ESTATES AT CATHEDRAL PINES
WINSLOW DRIVE
BLACK FOREST, CO 80908
AMENDED DEVELOPMENT PLAN

DATE: 12/13/2022
 DESIGNED: GEM
 CHECKED: WFG

SHEET TITLE:
LANDSCAPE PLAN

ESTATES AT CATHEDRAL PINES
WINSLOW DRIVE
BLACK FOREST, CO 80908
 AMENDED DEVELOPMENT PLAN

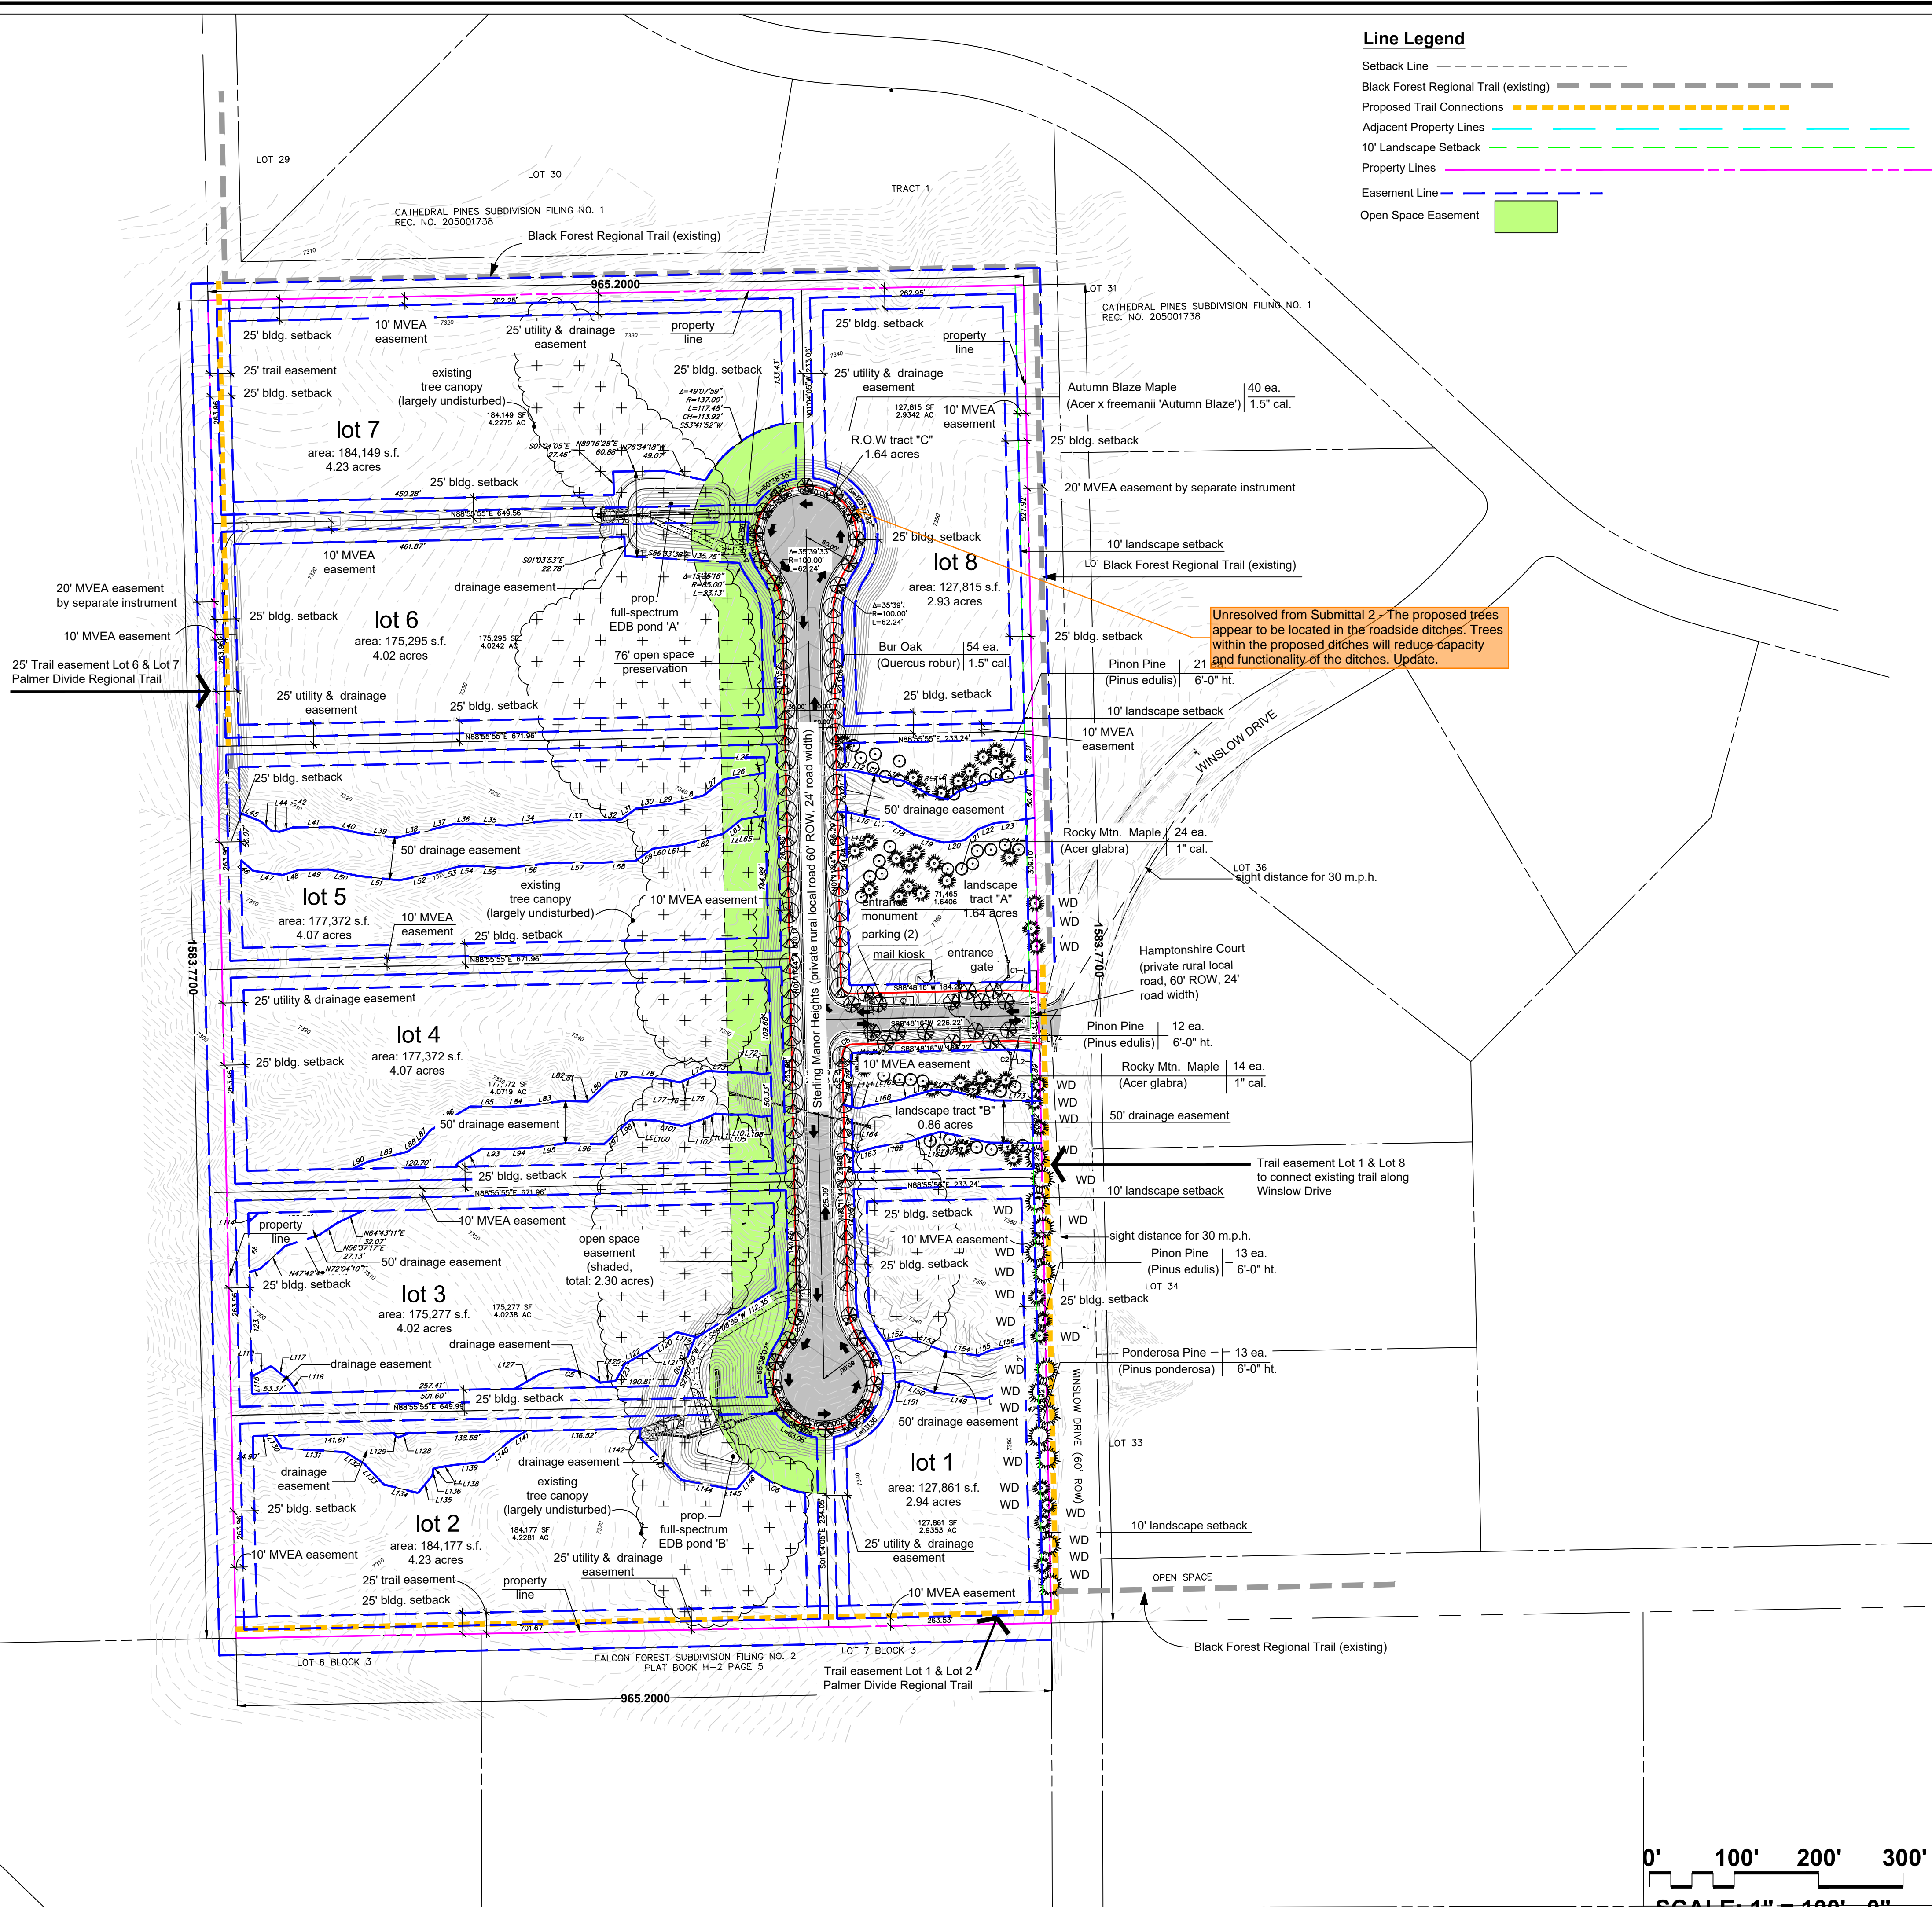
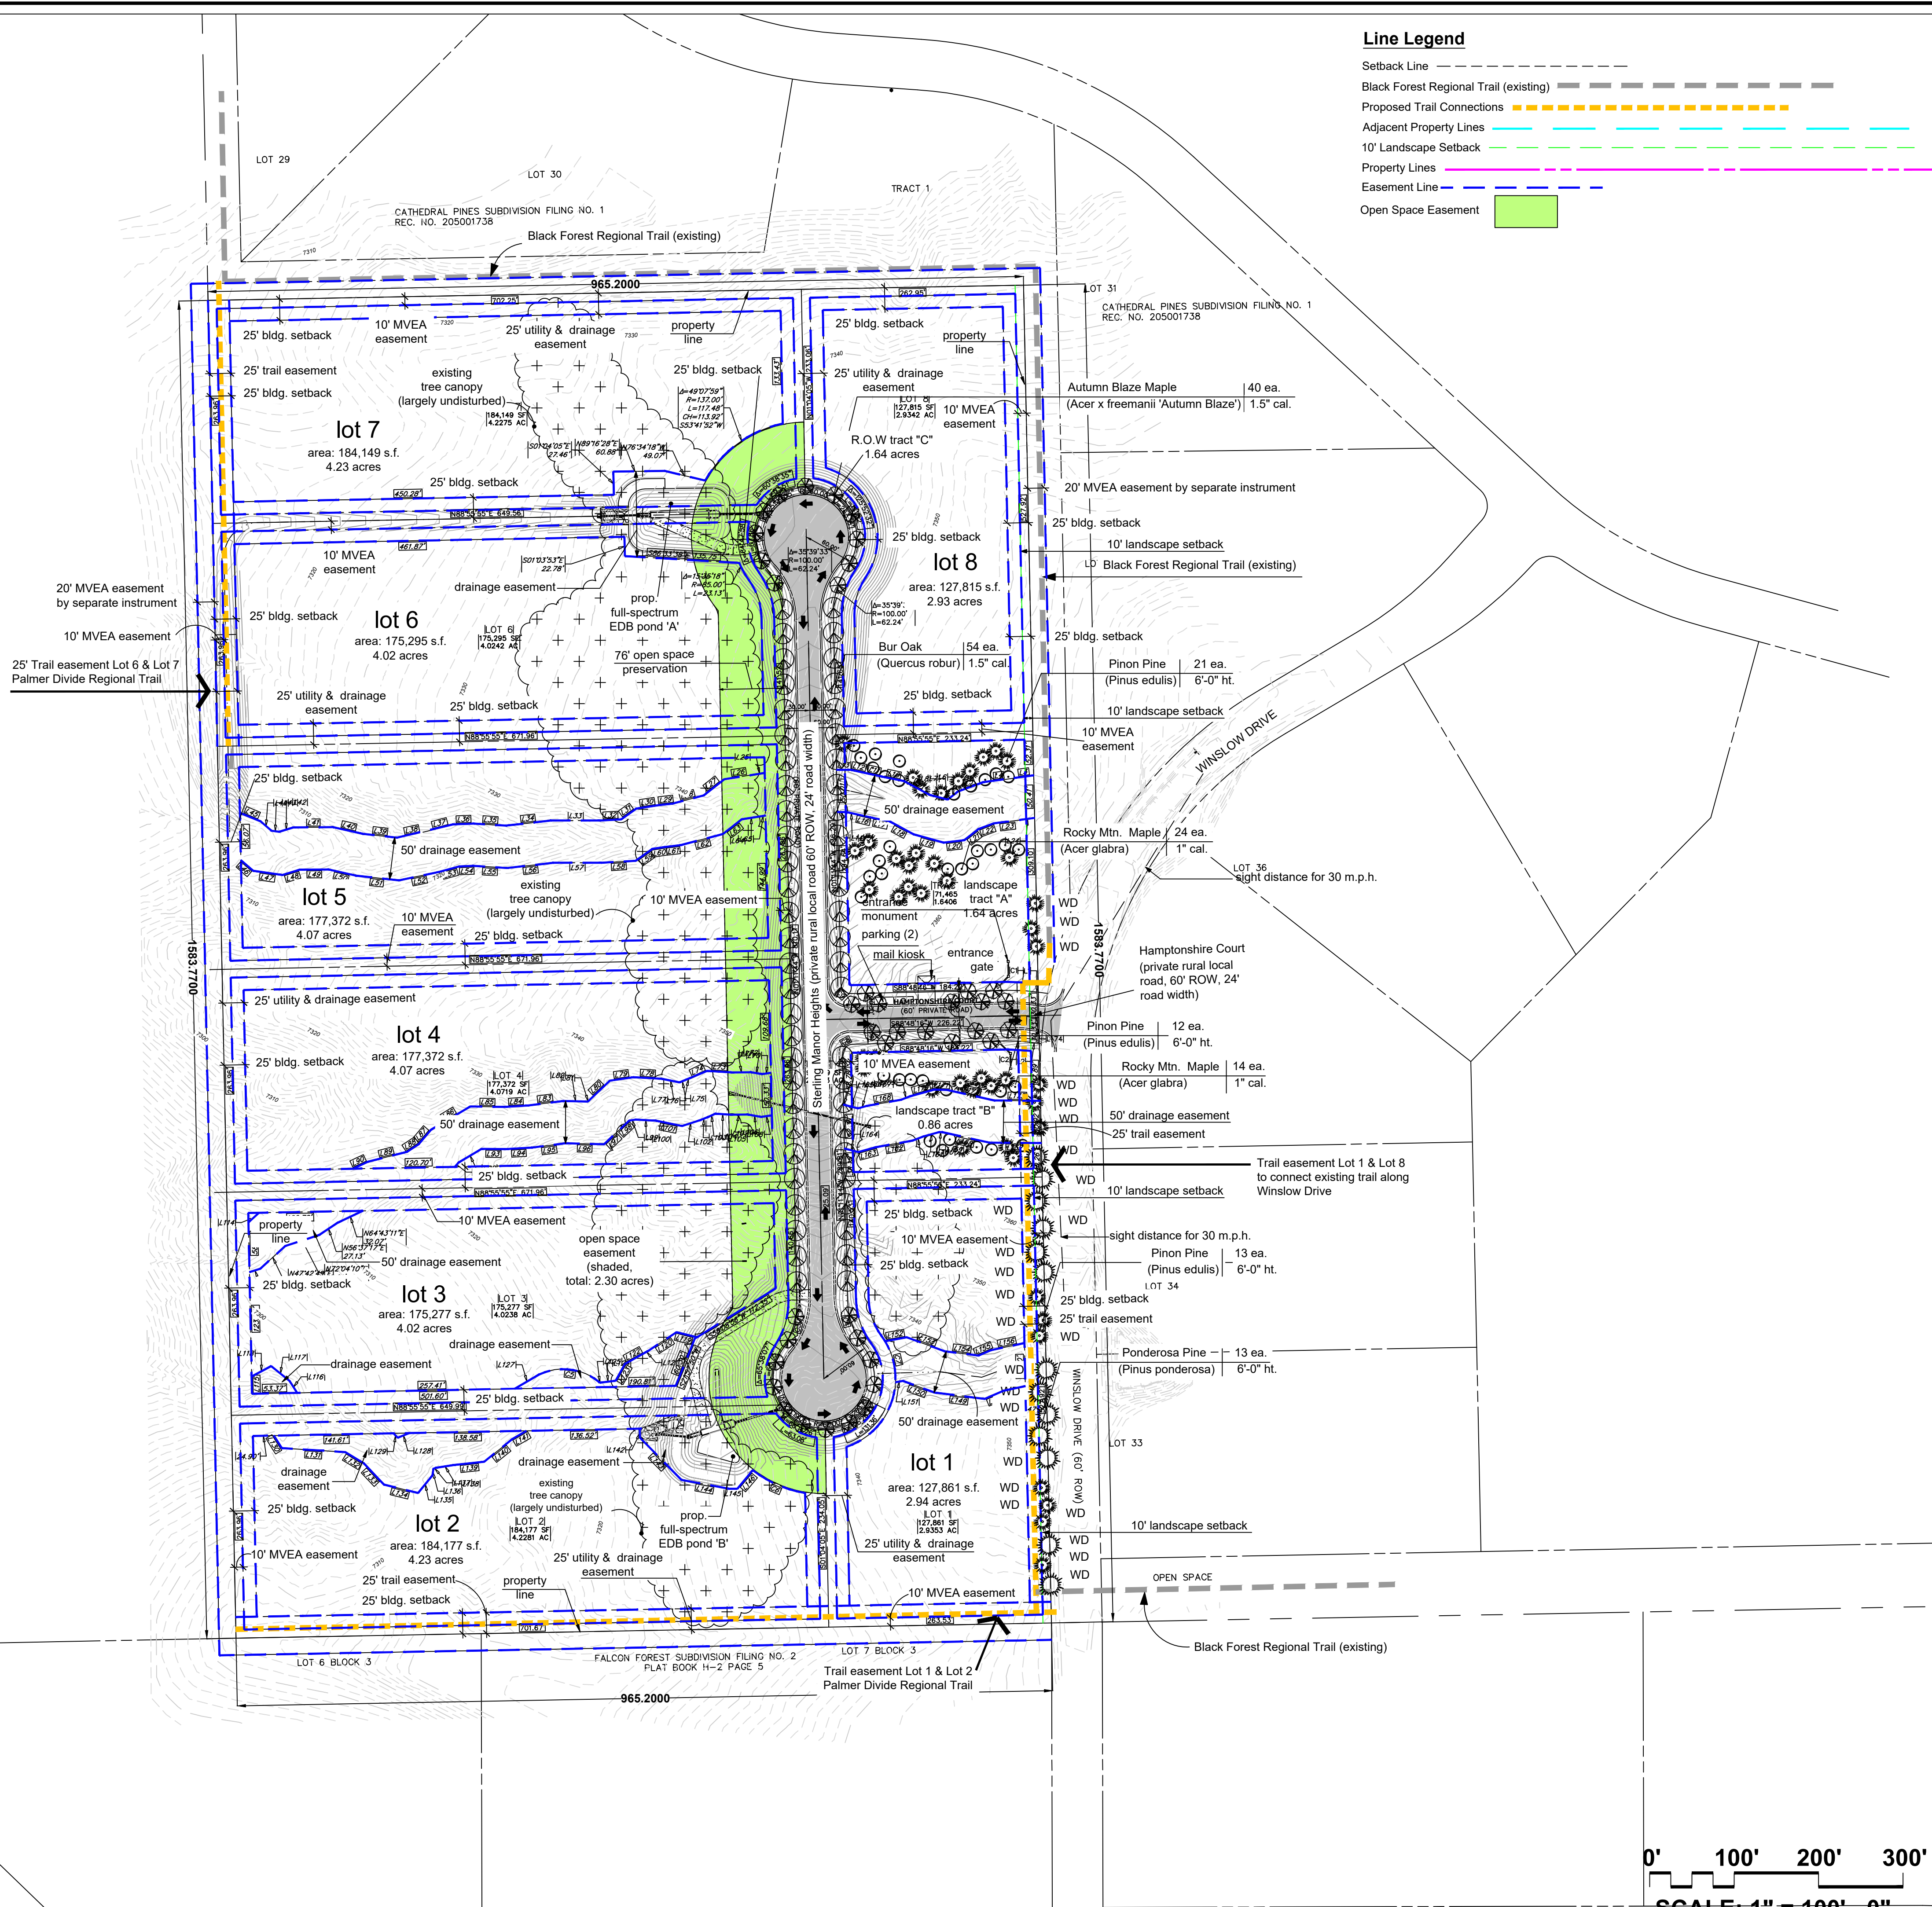
Street trees are required along all roads per the landscape section of the Code. This includes the proposed north-south road and the entrance road, and the portion of Winslow Drive that has already been provided for.
